DECISION DELEGATED TO DEVELOPMENT MANAGER

Application No:	H16-0266-21	Applicant:	Hutchison UK Ltd
Proposal:	Proposed 15m Phase 8 Monopole C/W wrapround cabinet at base and associated ancillary works		
Location:	Hawthorn Bank Spalding		
Terminal Date:	7th May 2021

Title: 210 PROPOSED H3G SITE PLAN

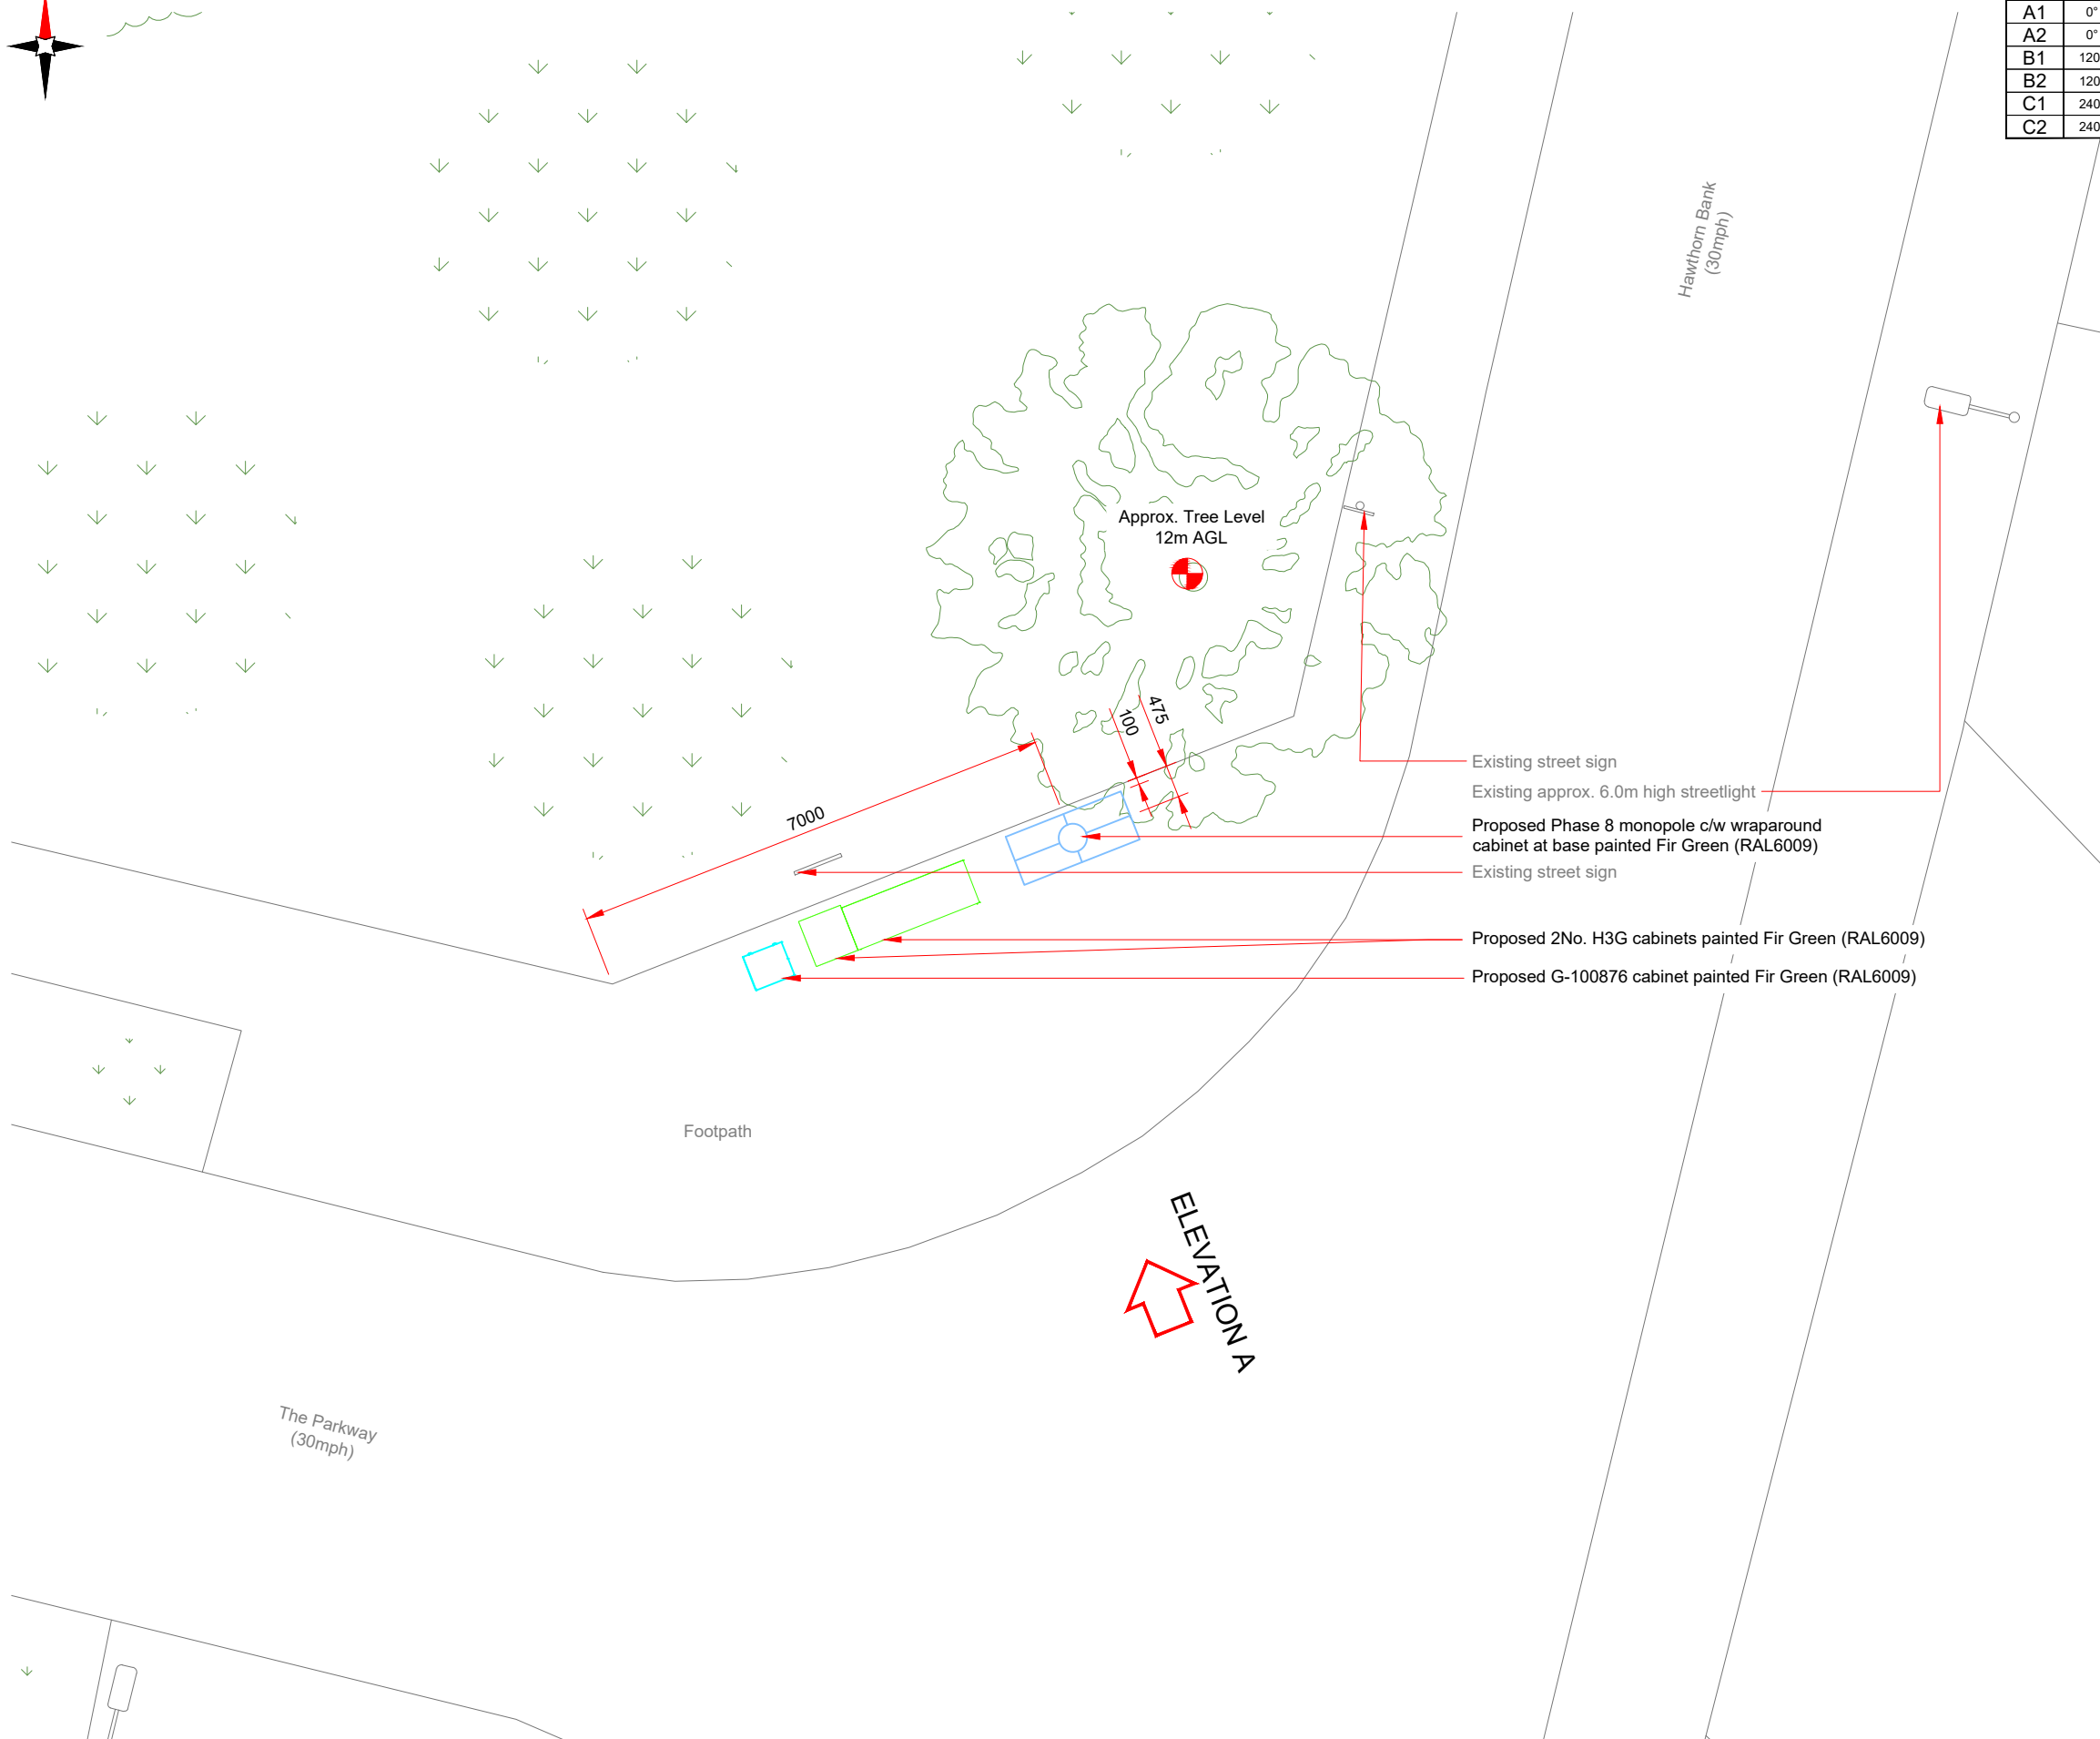
In terms of its siting, the proposed monopole, at 15 metres in height, would be readily visible in the street scene and the scale is not comparable to any other structure or building in the vicinity, being above the trees and roof line of properties in the vicinity. The 'wraparound cabinet at base' would be approx. 1.6m high, 1.8m wide and 0.75m deep. This would be sited just outside the maximum 15m Root Protection Area of the preserved trees to the north.

Furthermore, although it would be sited at the edge of the footway, it would appear visually detached from any other existing feature on the street scene due to the grassed area to the north between the site and property boundary. In addition, the site is in reasonably close proximity to preserved trees which have, in part, been protected for their visual amenity value. The proposed development would negatively impact this.

Title:
260 PROPOSED H3G ELEVATION

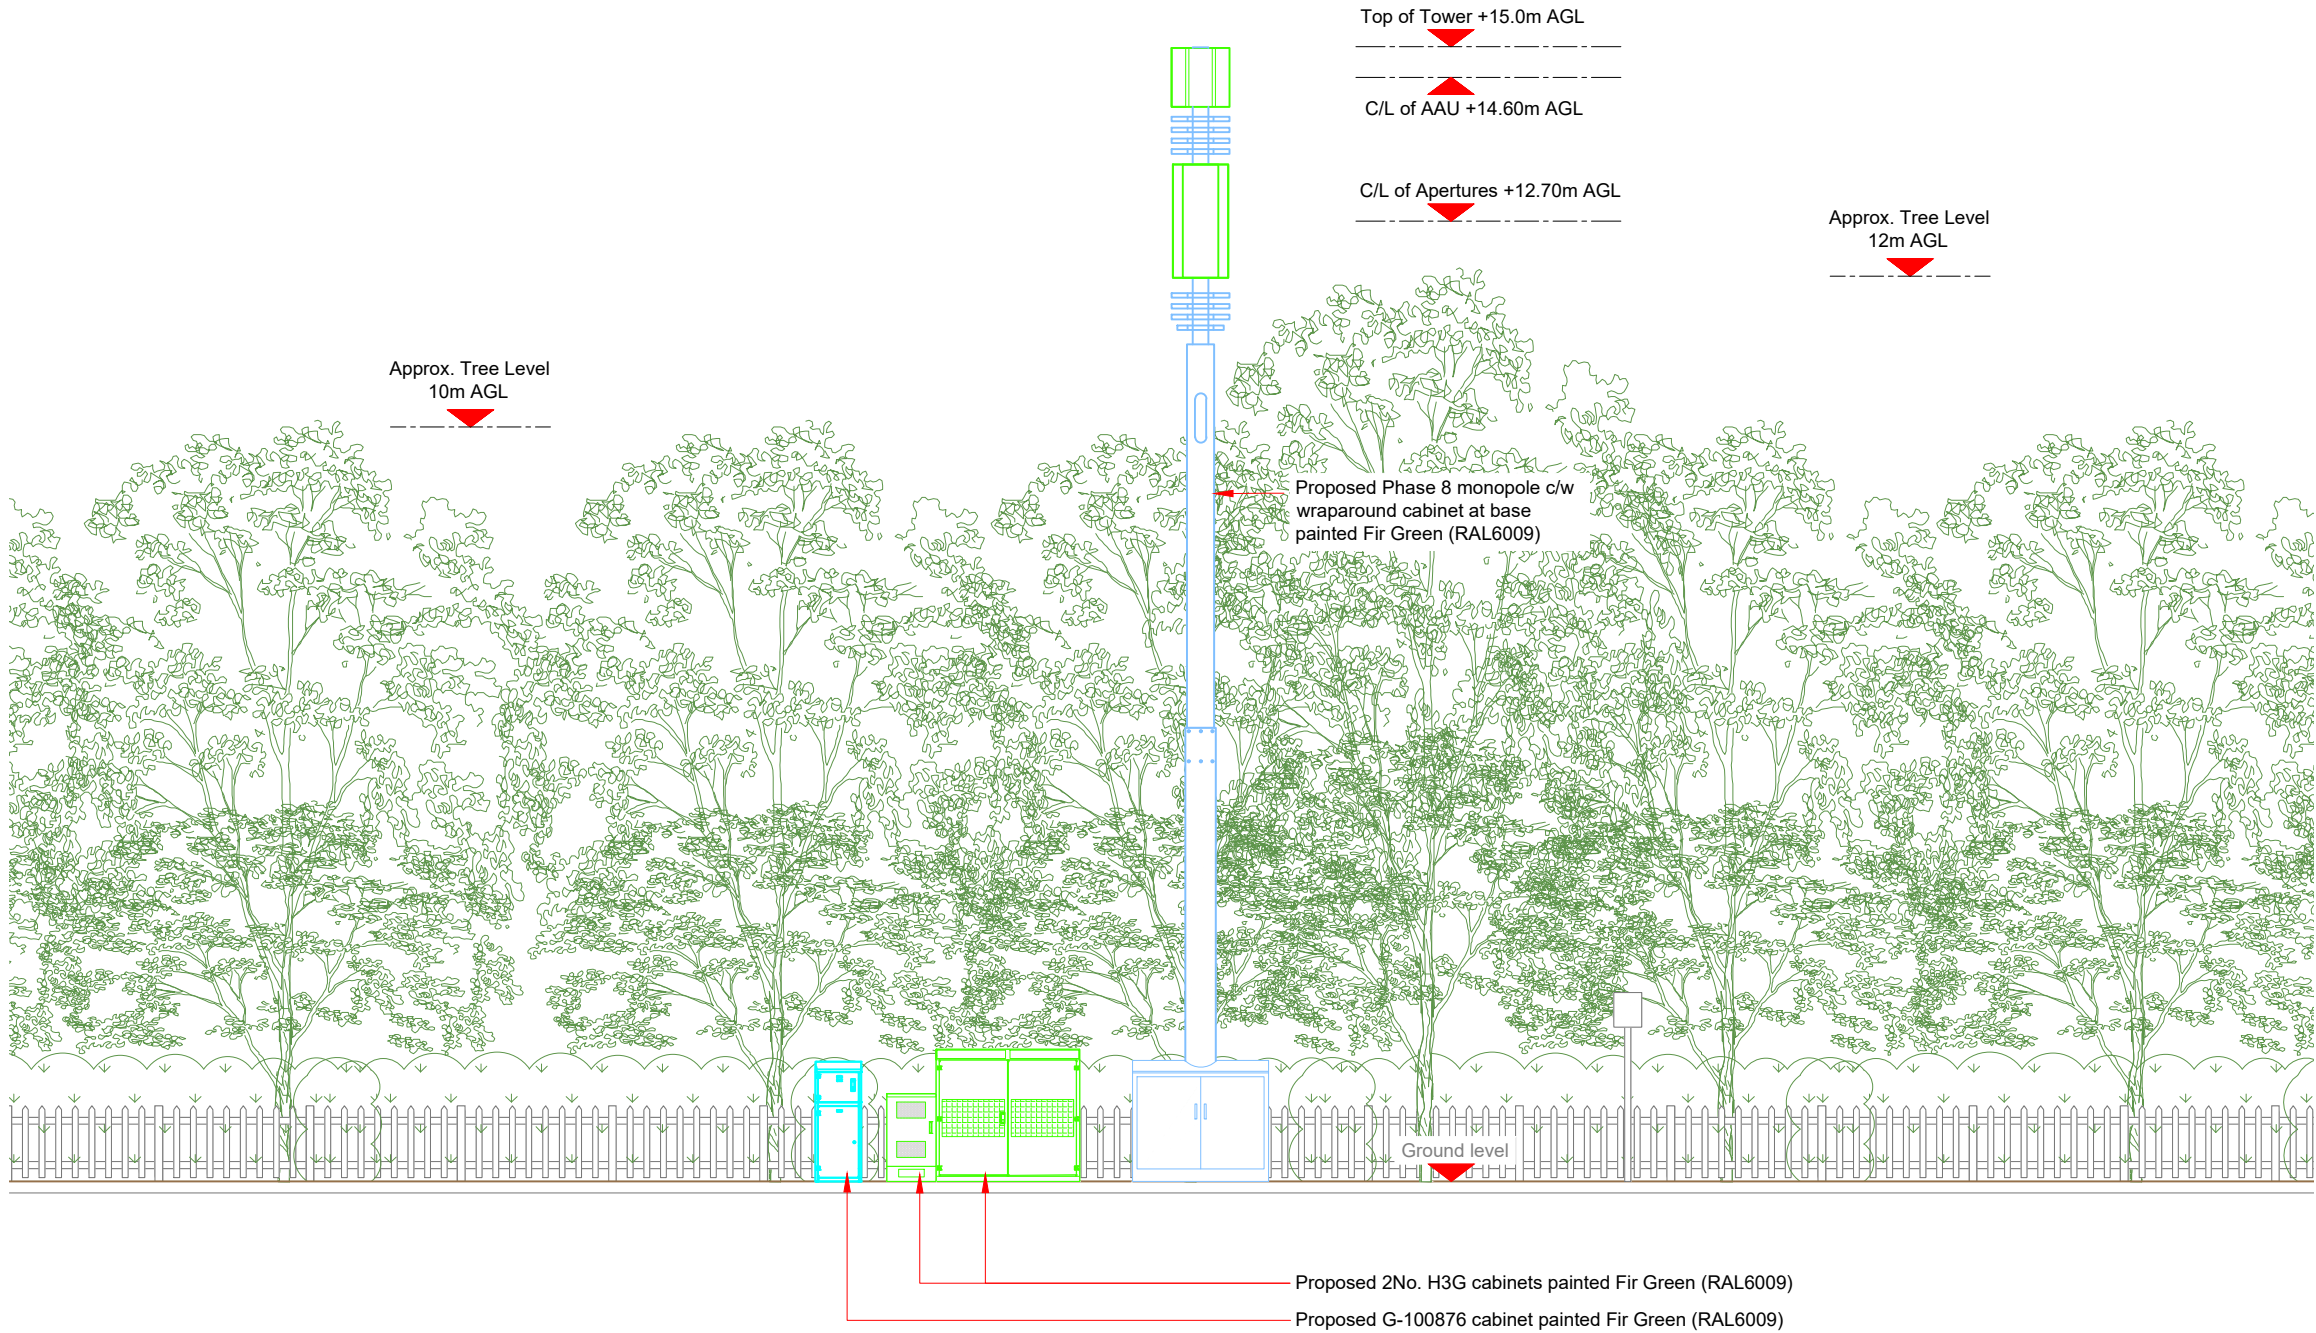
Whilst it is accepted that there is other street furniture in the vicinity (such as street lights, road signs and telegraph poles), it is considered that the proposed development would have a material adverse impact on the wider street scene due to it being an unduly dominant, obtrusive and alien feature within the street scene. The proposal would sit in a prominent position within a large footway at what is, at times, a very busy junction due to the proximity to the nearby primary school. It would therefore be visually obtrusive to pedestrians and motorists alike.

In terms of longer views, the mast would likely be visible up to approx. 160m west on The Parkway and would therefore be visually prominent when viewed from that direction. However, the mast would be less prominent at a distance on Hawthorn Bank as it would be obscured by existing trees and vegetation and would be against the backdrop of the protected trees to the rear.

The proposed monopole has been reduced in height during the course of the application from 18m to 15m. It does not exceed the height limitation set out and is therefore Permitted Development. However, as per A.2(3) of Class A of Part 16, development under Class A of Part 16 is permitted subject to the conditions set out in paragraph A.3 (prior approval). Paragraph A.3 sets out that before beginning the development, i.e. the installation of the monopole, the developer must write to the Local Planning Authority for a determination as to whether the prior approval of the authority will be required as to the siting and appearance of the development.
